**Sterling Recycling Facility
Transportation Memorandum
PCD File No.: PPR2241
(LSC #S224330)
August 24, 2023**

RE: Sterling Recycling Facility
Transportation Memorandum
El Paso County, Colorado
PCD FILE NO.: PPR2241
LSC #S224330

STERLING RECYCLING FACILITY
STREET PLAN & PROFILE

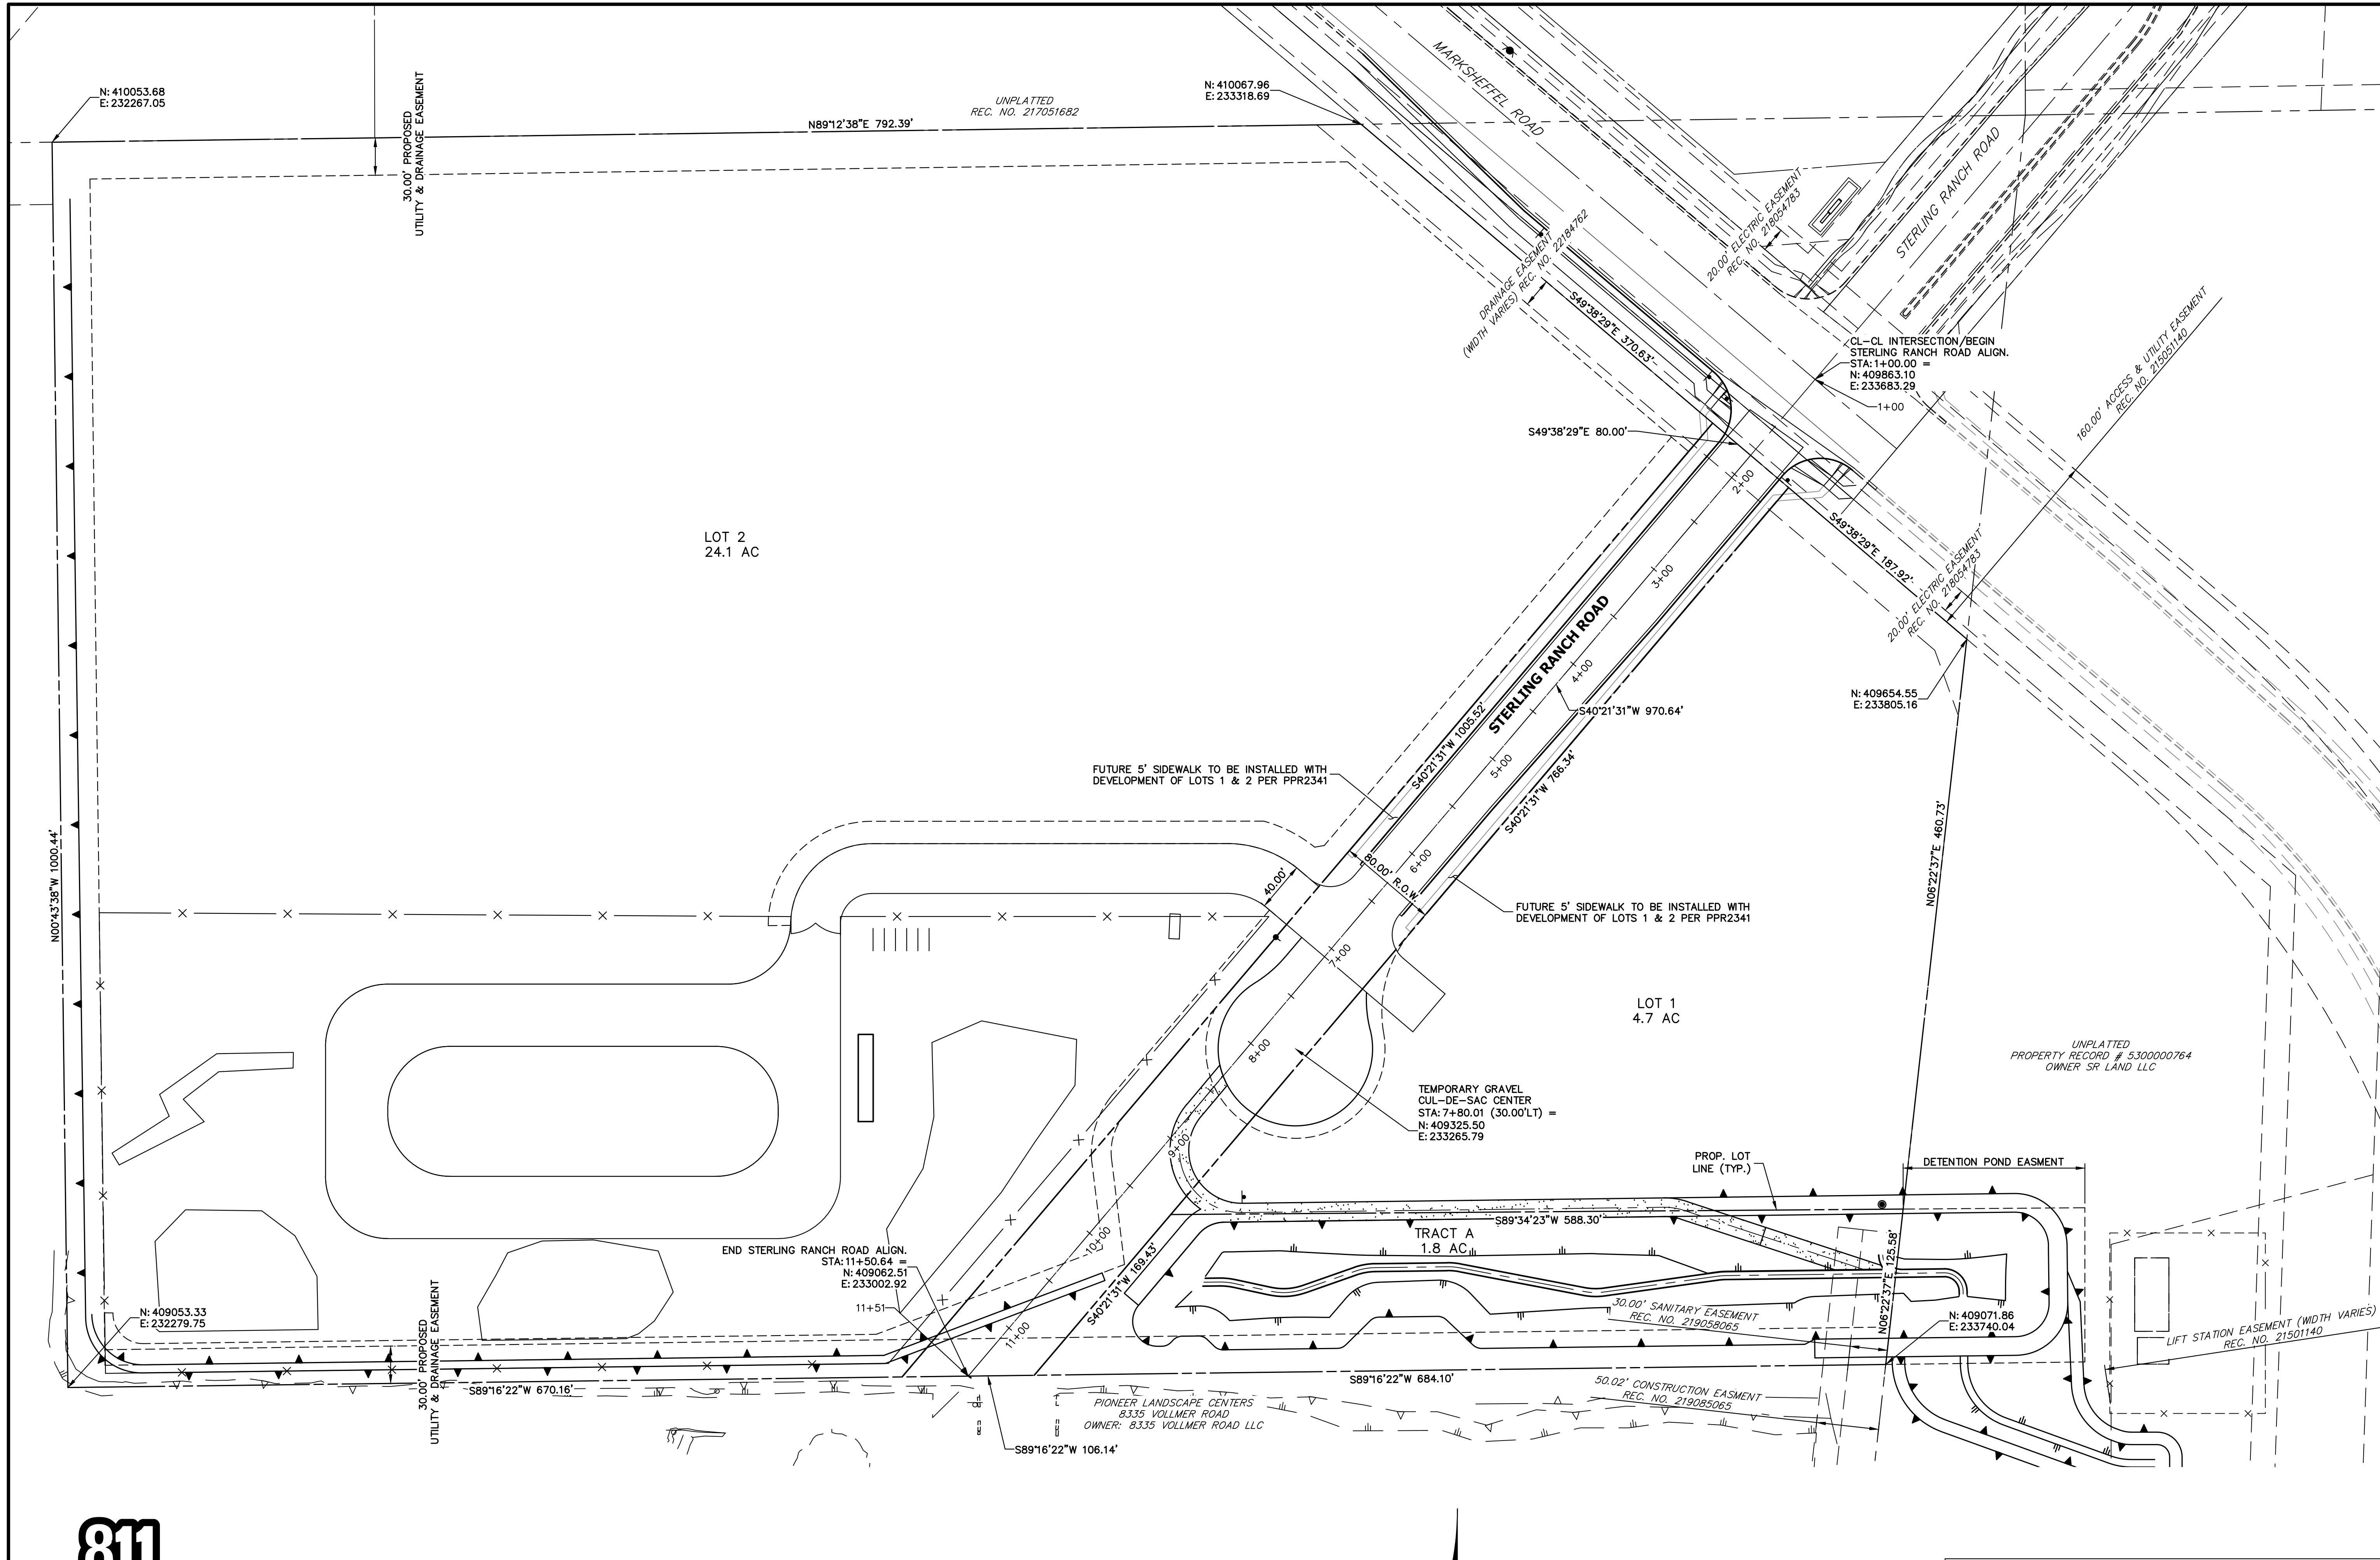
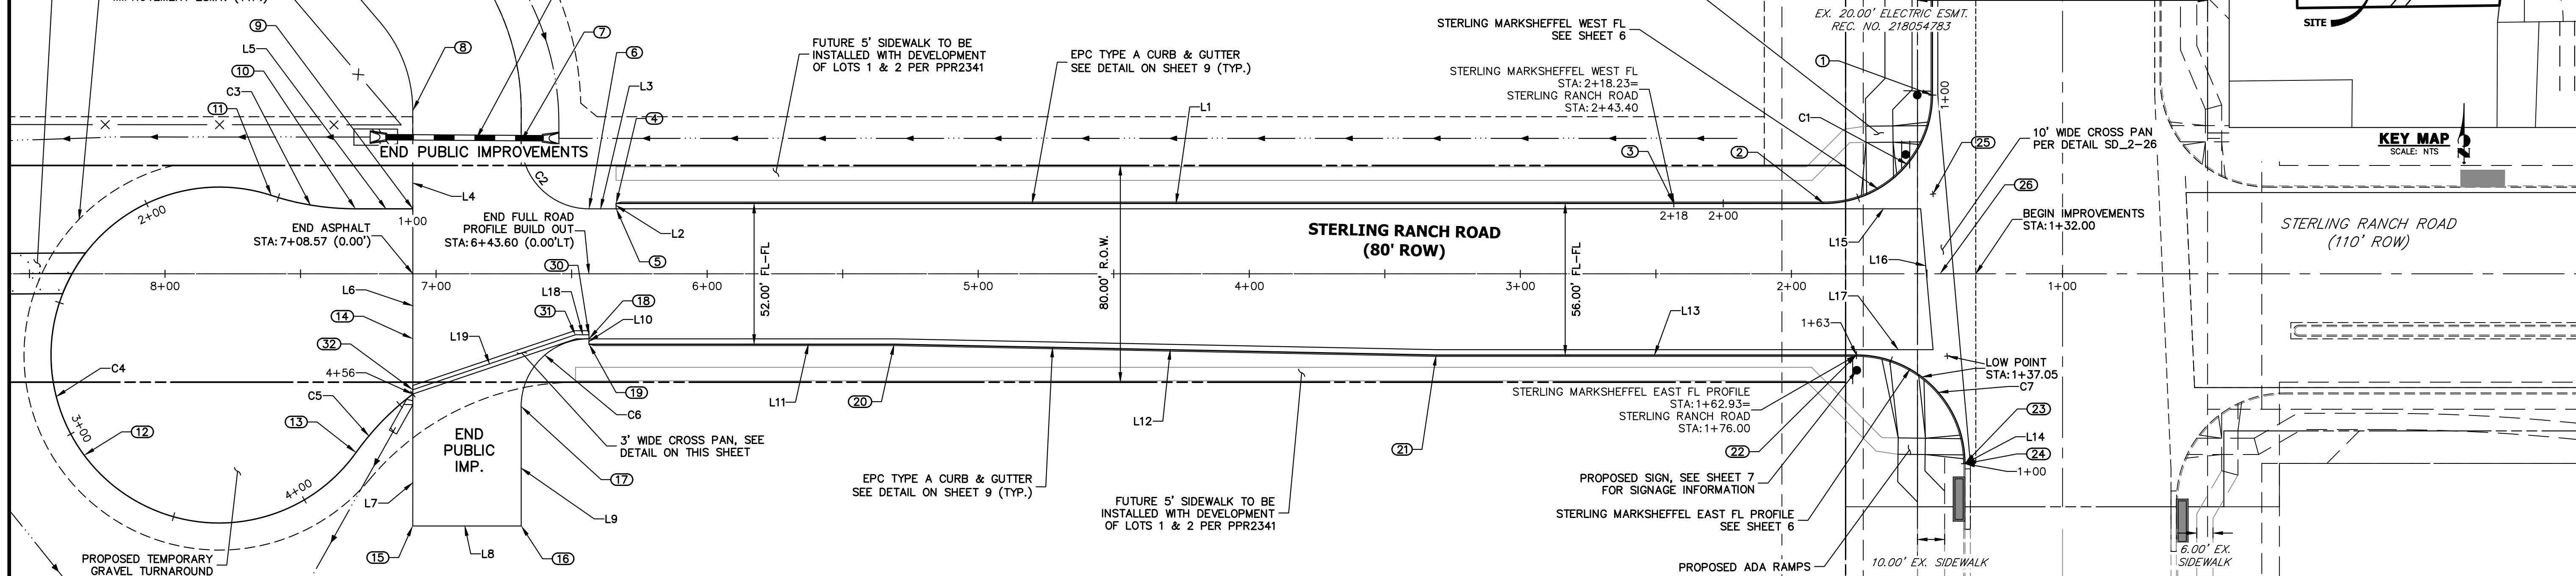
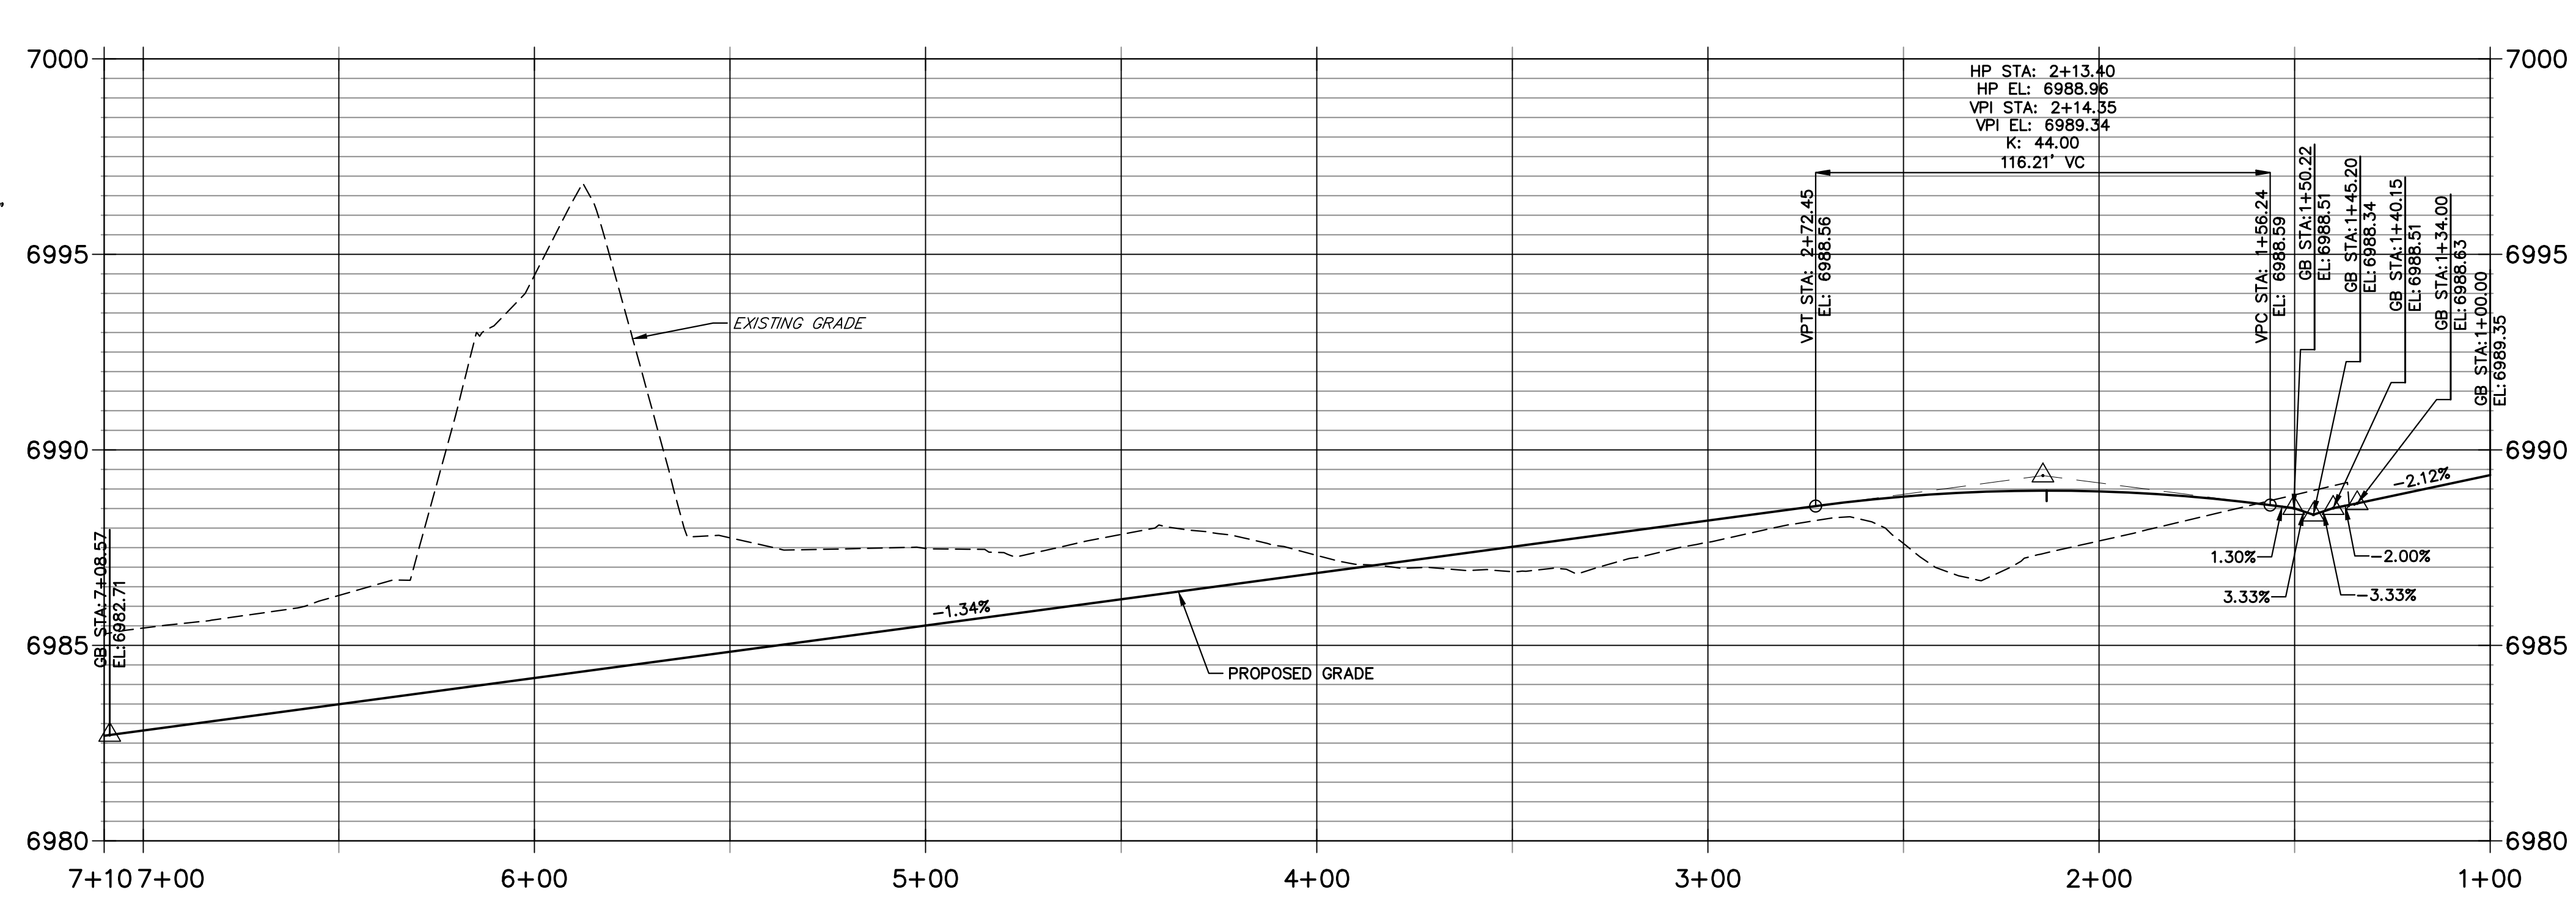
Please address access spacing for LOT #1 and proximity to Marksheffel along Sterling Ranch. Dependant on lot use type and traffic generation does this spacing meet requirement or should the access be moved further south close to the temp Cul-de-sac and a possible full movement with Lot #2. Spacing is only ~140ft and inside the transition lane area for EB and SB right turn onto Marksheffel. Left turns into LOT #1 do not seem to be addressed
